KITTITAS COUNTY COMMUNITY DEVELOPMENT SERVICES

October 20, 2021

Subject: Tiger (LPF-21-00010) Final Long Plat – Return of Application

LP-08-00022

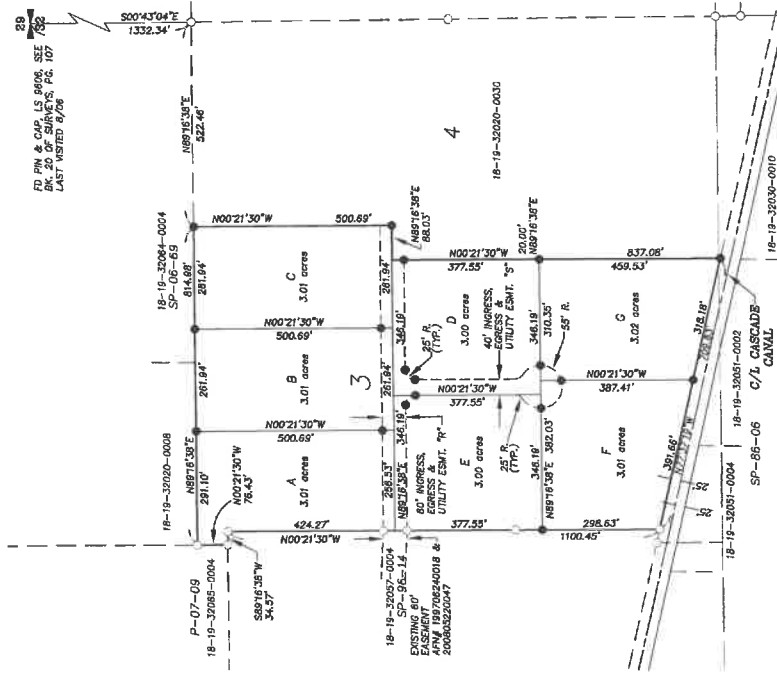
- All taxes for the applicable parcels associated with the final plat application must be paid prior to CDS signature.
- The face of the final plat shall include both the preliminary and final approval file numbers (LP-08-00022 and LPF-21-00010)

- The parcel owner listed on the second page of the plat map does not match the ownership registered with Kittitas County on TaxSifter.
